TOWN AND COUNTRY PLANNING ACT 1990 FULL

Reference: H18-1047-24 **Date of Decision:** 31st March 2025
Applicant: Mr T Bissett
C/O Peter Humphrey Associates Ltd
2 Chapel Road
Wisbech
PE13 1RG
Location: Workshop Rear Of 9 New Road Fronting King Street Sutton Bridge Spalding
Description: Proposed workshop conversion to dwelling, including lifting of existing roof

South Holland District Council hereby give notice that this application has been REFUSED for the above proposal for the following reason(s):

Proposed Section 1:50

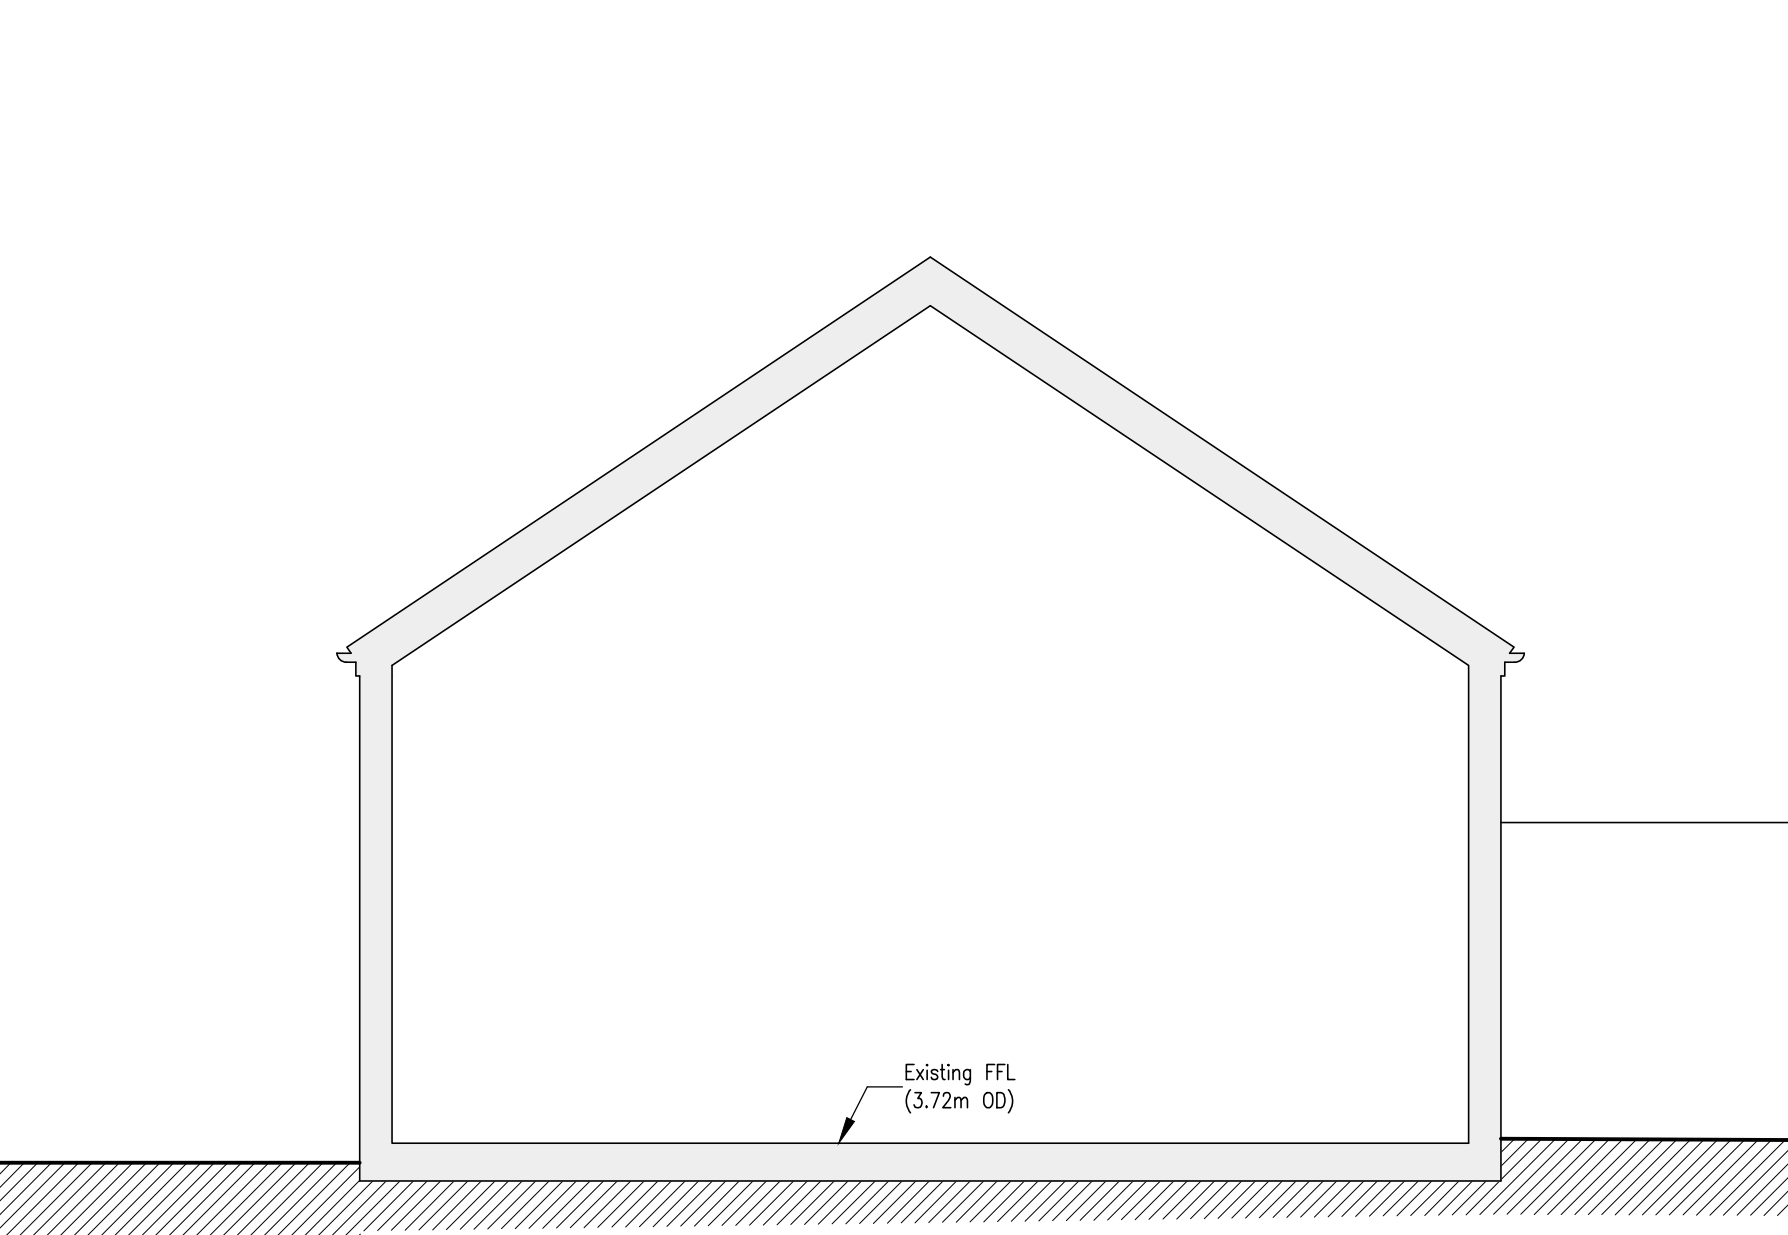
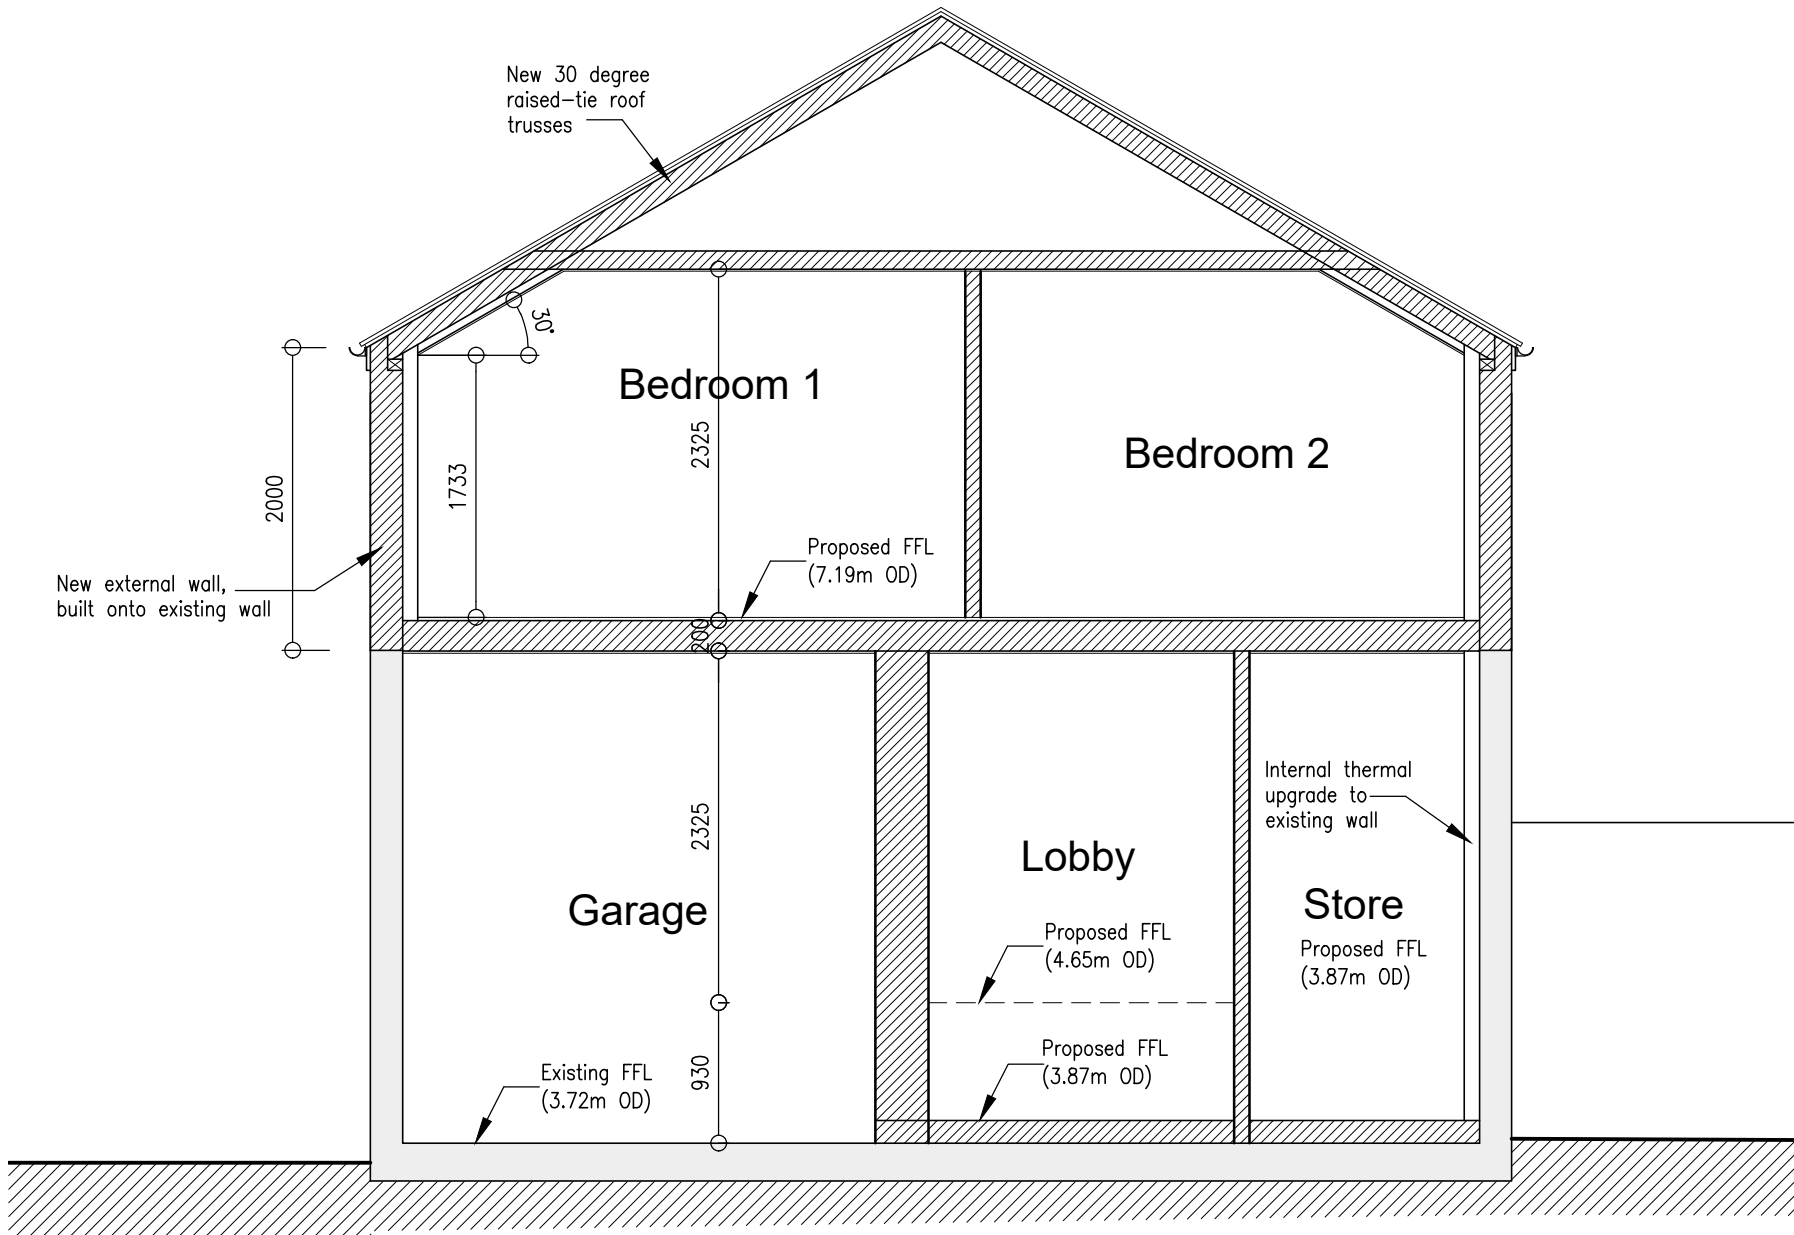
Due to the recommendations of the Flood Risk Assessment, requiring the finished floor levels of a resultant dwelling to be set at 1m above ground level, coupled with the Environment Agency's comments that the property must be two-storey in scale, this would cause any proposed dwelling on site to materially overshadow the existing rear garden of 9 New Road, due to the positioning and locations of the plots, and would result in an unacceptable impact on the residential amenities of the occupiers. Further to this, the windows located on the rear elevation would directly overlook into residential curtilage and garden of No.13 New Road. These windows would serve a living room and bedroom on the first floor and a family/dining area on the ground floor, plus a landing, comprising accommodation that would be regularly utilised which would provide outlooks and overlooking the 1.8m high boundary wall. This would result in an adverse loss of privacy.

Proposed Site Plan 1:250

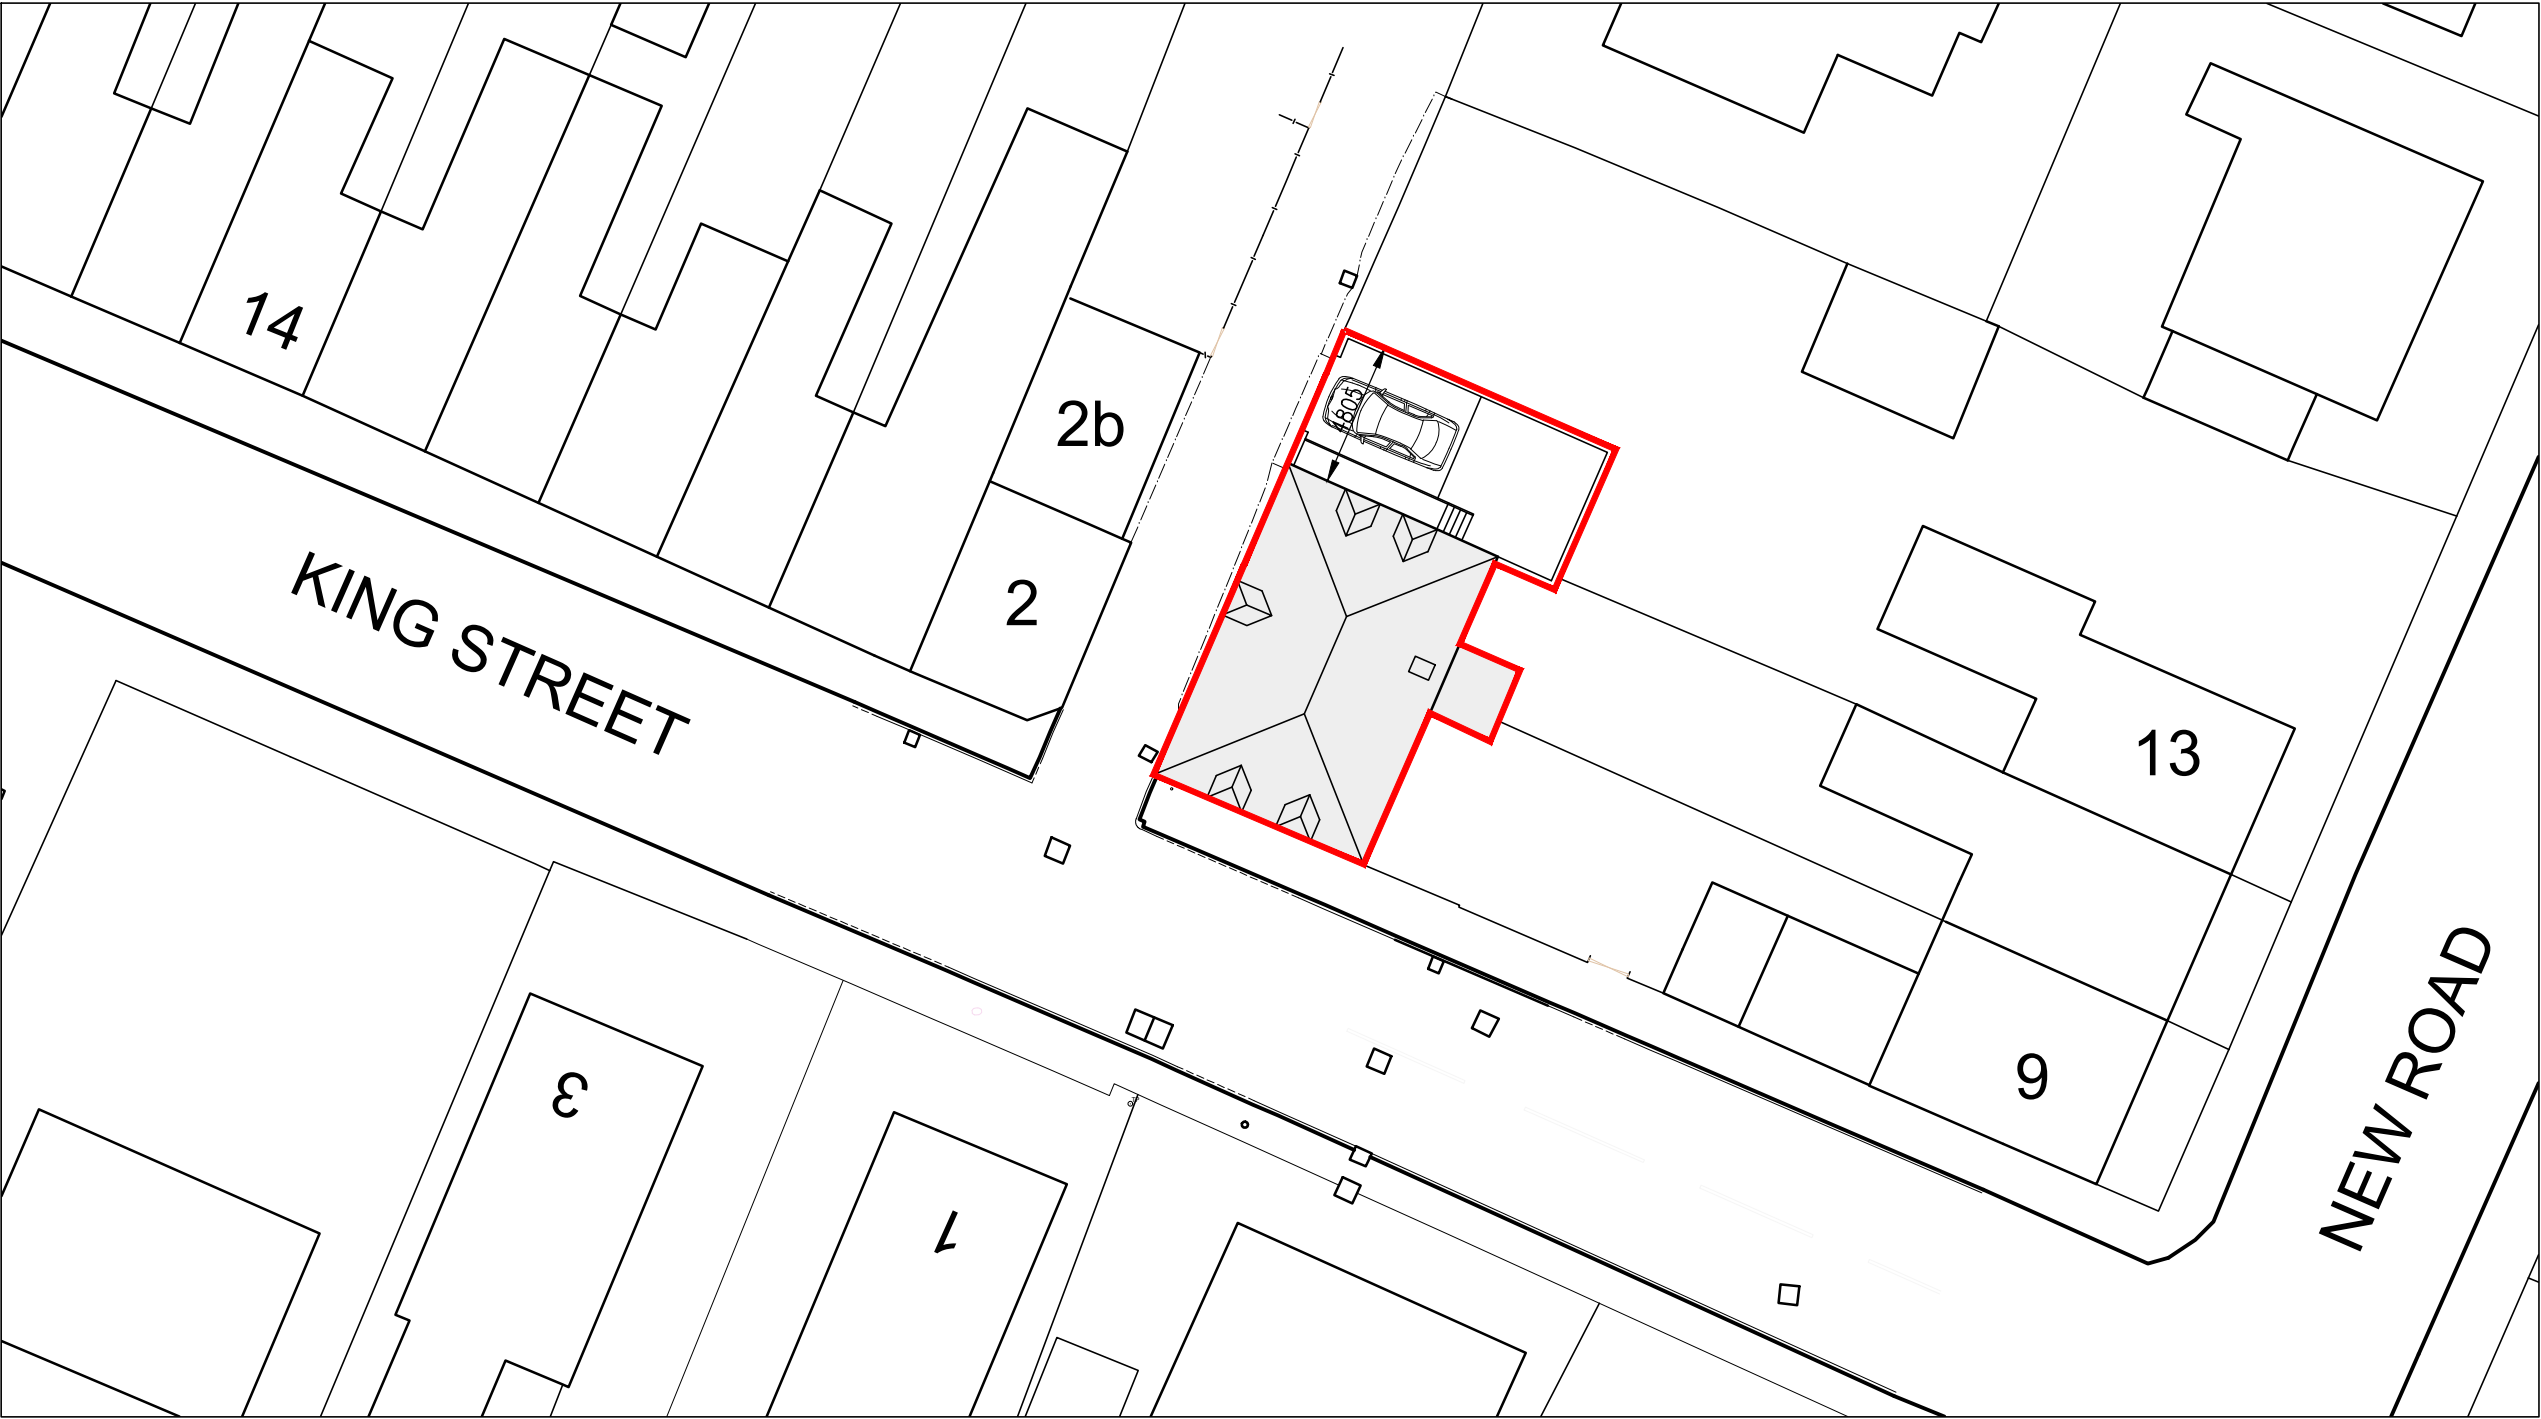
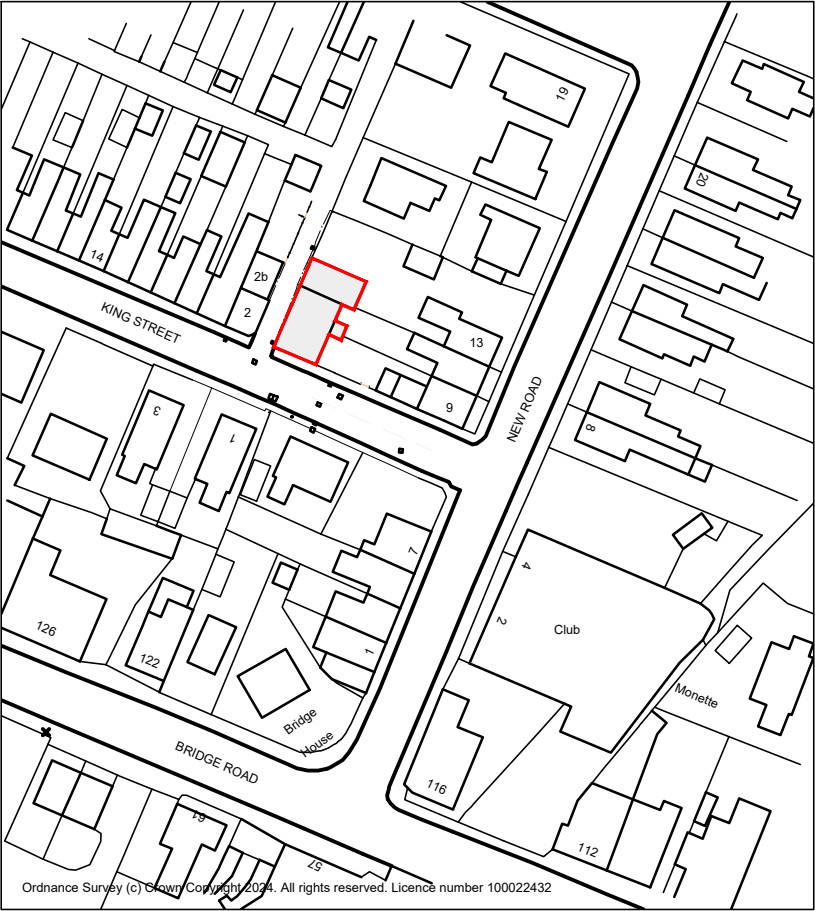
Due to the small and contrived size of the plot, the proposed conversion would result in a cramped form of development. The previous refusal on the site, although proposed to demolish and rebuild, stated 'From this it is considered that any potential dwelling being located as a result of the demolition of this workshop would appear cramped and contrived due to the minimal capacity it has to offer'. It is still considered that the plot is too small, and would be unsuitable to constitute an independent dwelling due to its size. It would not be consistent with the current built form and designs along both New Road and King Street due to their designs featuring terraced properties with long gardens and detached houses on larger plots.

As a result of this, by virtue of its size and density, the location of a dwelling within this plot would appear as a cramped and contrived form of development, with minimal options to alter the scheme. The proposal is not considered to be acceptable.
